**From:** Holly Duncan  
**Sent:** Tuesday, August 28, 2012 4:47 PM  
**To:** Jeff Watson  
**Subject:** RE: BL-12-00023 Jones

**From:** Jeff Watson  
**Sent:** Monday, August 27, 2012 1:52 PM  
**To:** Christina Wollman; Brenda Larsen; Jan Ollivier; Holly Duncan  
**Subject:** BL-12-00023 Jones

BOUNDARY LINE ADJUSTMENT

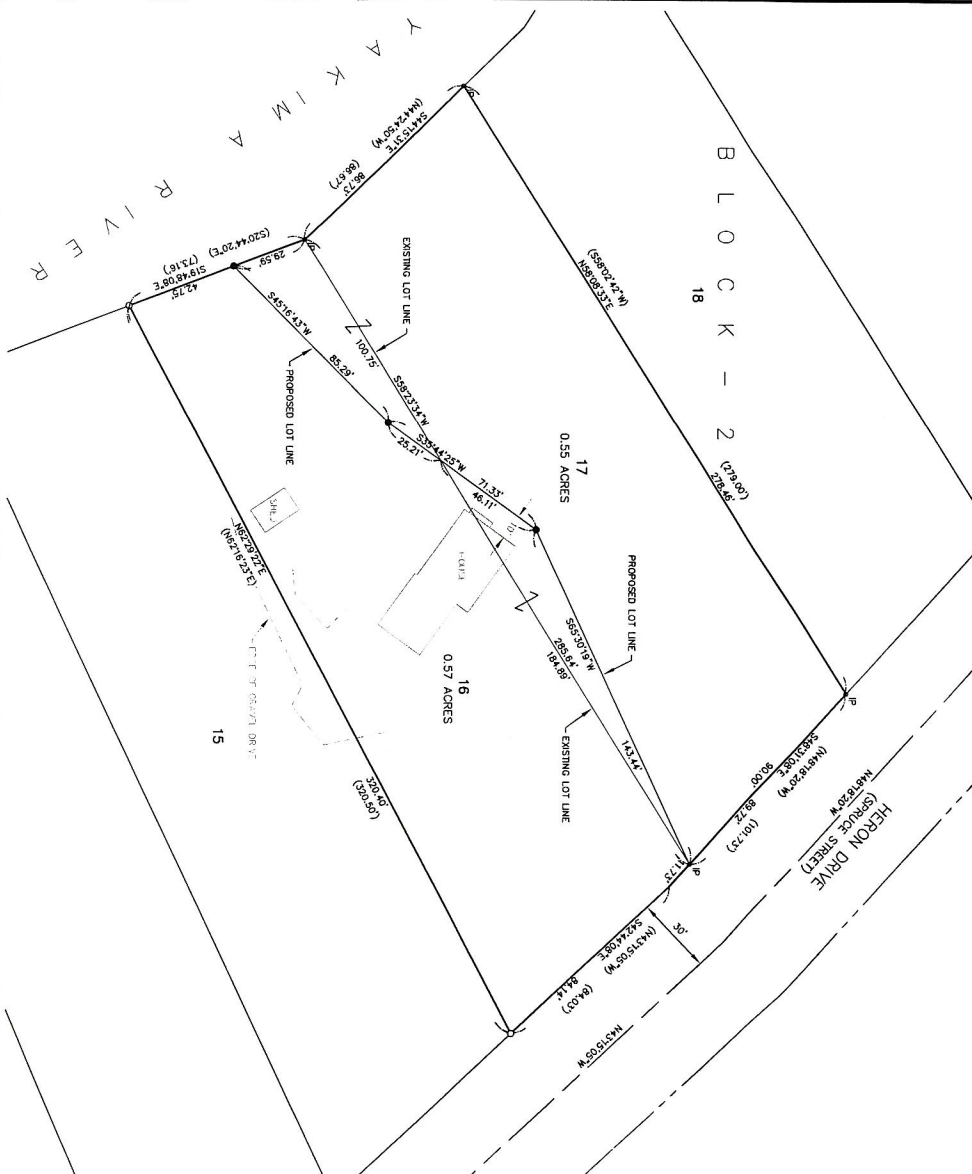
In reviewing this application I have some question as to where the existing drainfield is in relationship to the proposed lot line. I pulled up an as built that shows the two, 30 foot drain field lines being located between the house and the shed somewhere and need to verify that the setback from the property line to the drain field lines is met.
